25 March 2013
Our Ref: 10034

Lakes Estate Residential Subdivision – Response to post PPR submissions – Major Project Application (05_129)

CHECKED	DRAWN	SCALE	
KS	DD	0 25 50 100 150m	
PROJECT NO.		DWG No.	REV. No.
912		A008	H

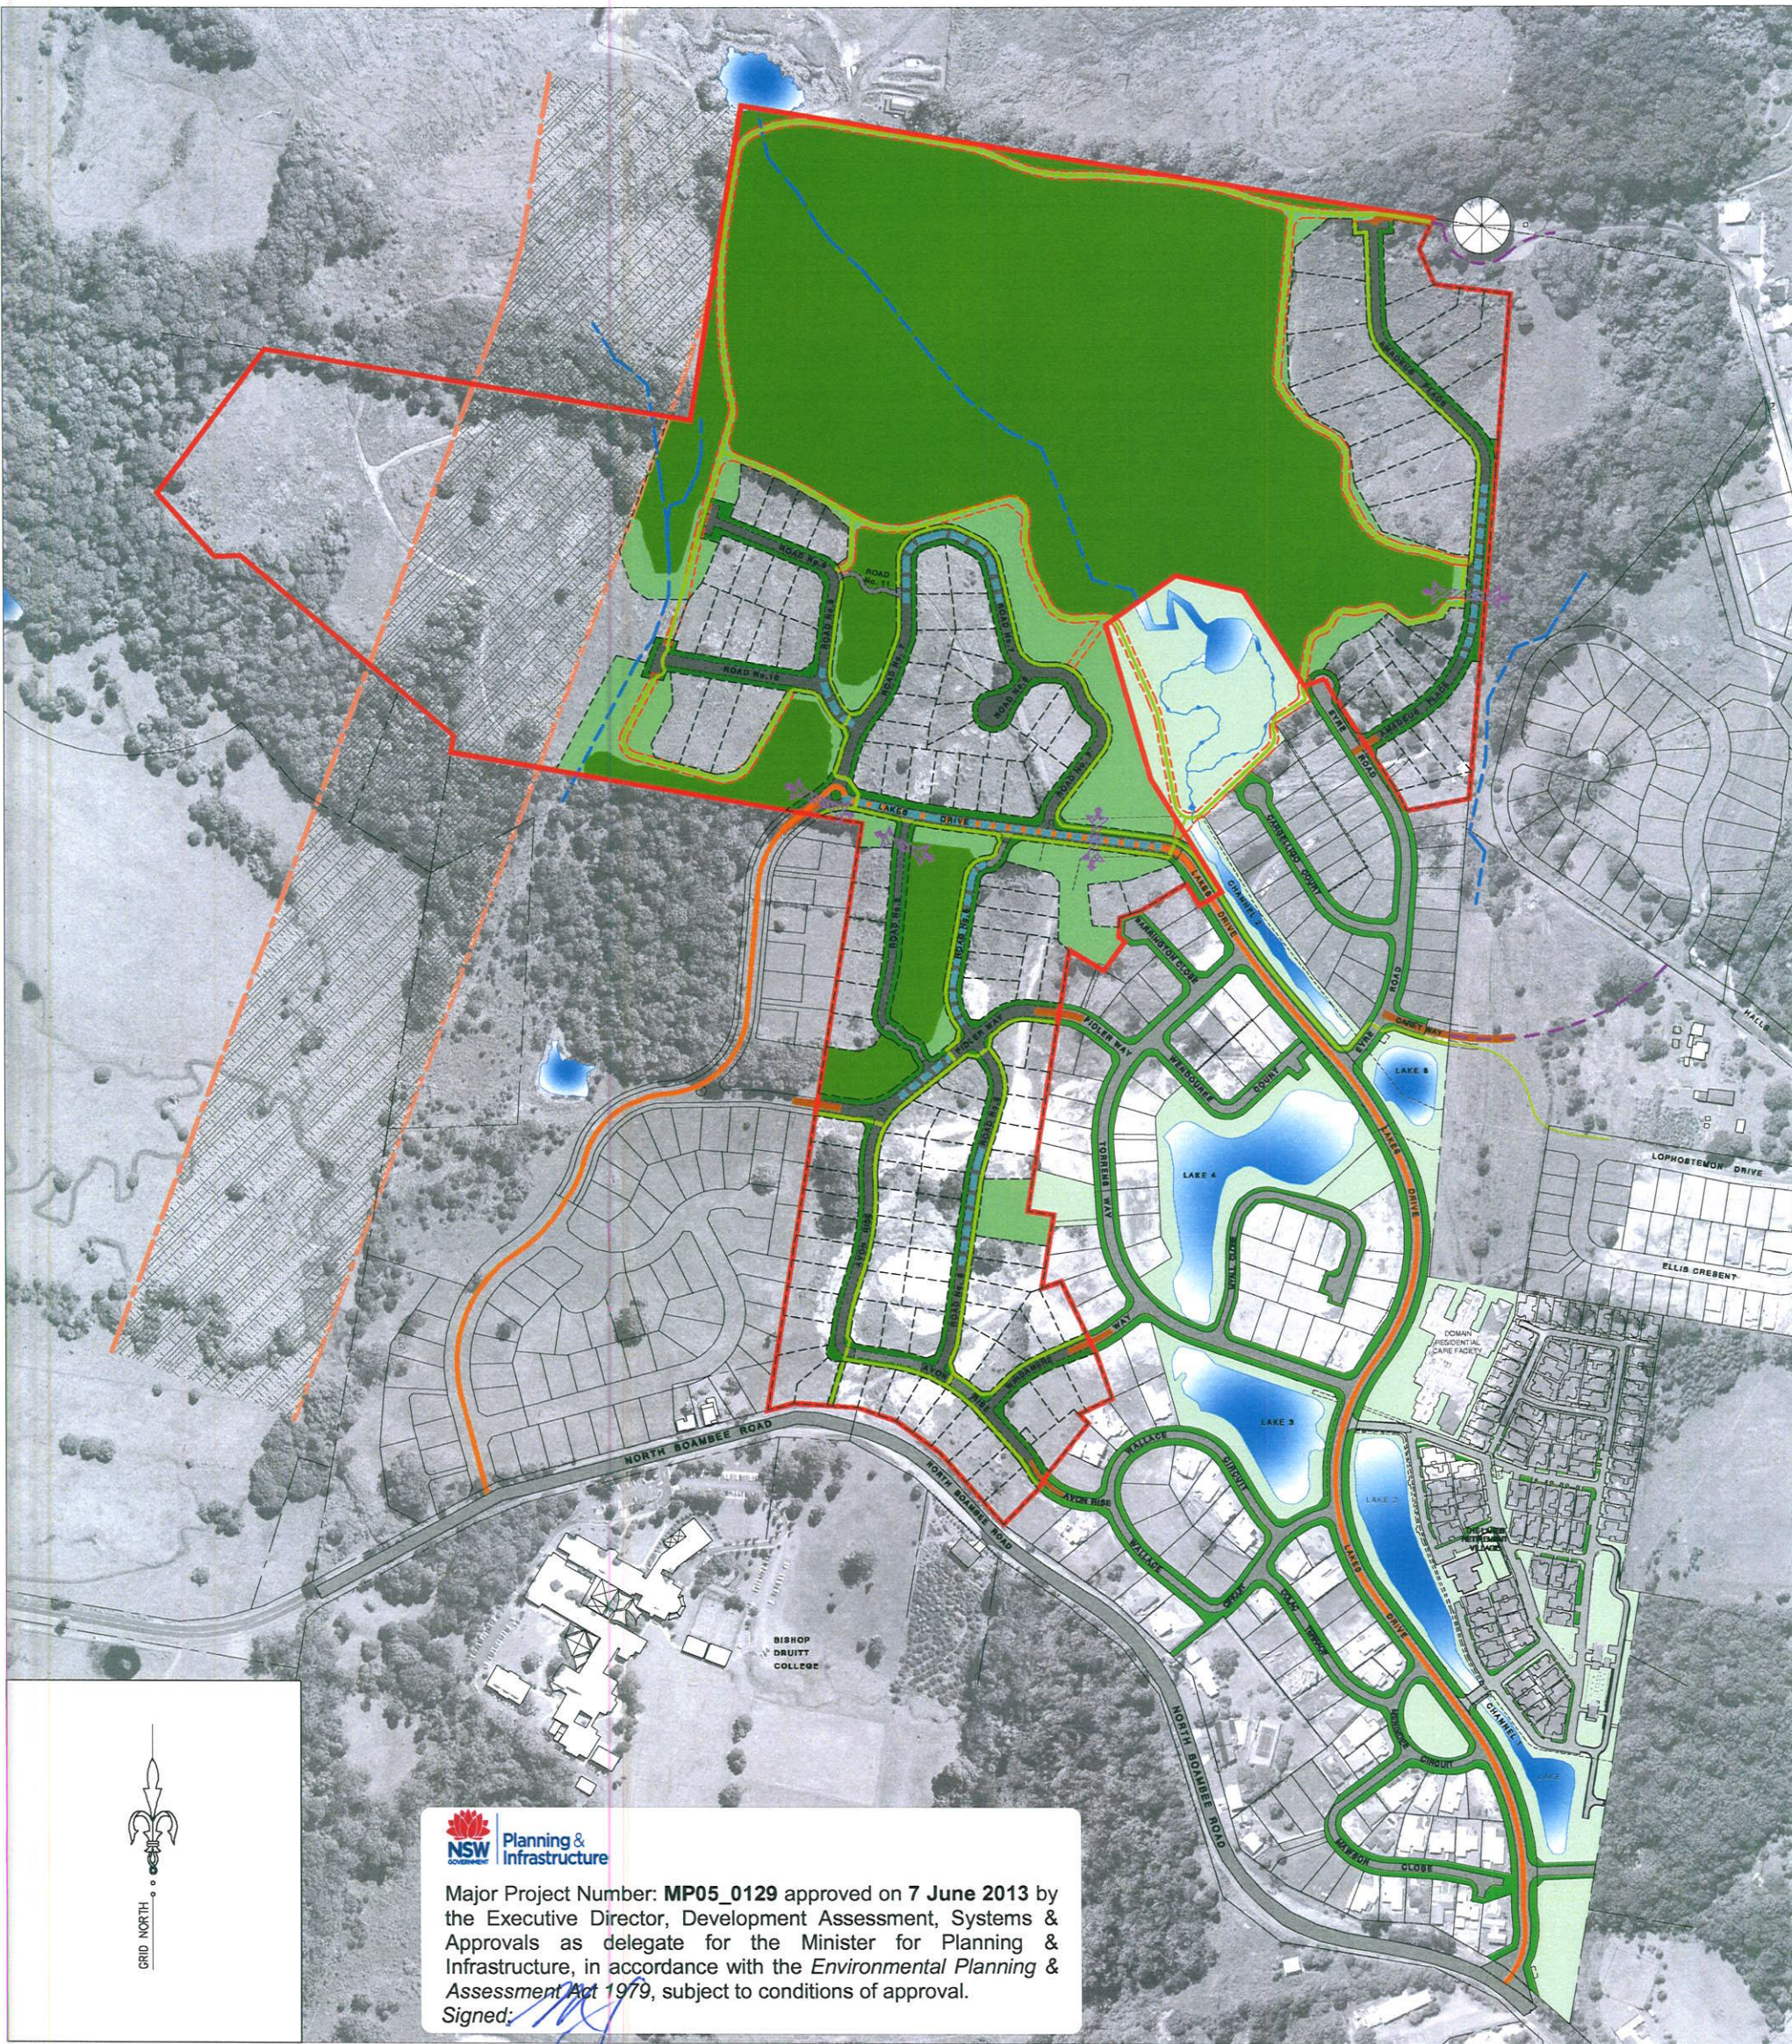
The additional pathways proposed by Council appear to enhance connectivity through the precinct, although it is unclear exactly where the pathways in the vicinity of lots 16 and 117 should be located.

C14. The proponent commits to a pedestrian and/or path network in the locations identified in the Roads and Movement Access Plan (912-A008 G).

An additional sentence could be added to C15 to clarify the consequence of modifications to the infrastructure that is proposed to be delivered. Commitment C15 can be amended to read as follows:

C15. The proponent commits to the payment of monetary contributions in accordance with the relevant sections of the CP. The total cash contributions to be paid would be off-set by the value of the public infrastructure land and works provided by the proponent through these commitments in accordance with the terms of the CP. The contributions to be paid and the works done will be quantified in a works-in-kind agreement, which may be negotiated prior to commencement of works (for each stage or a grouping of stages) and may incorporate modifications to the various infrastructure plans included in this approval.
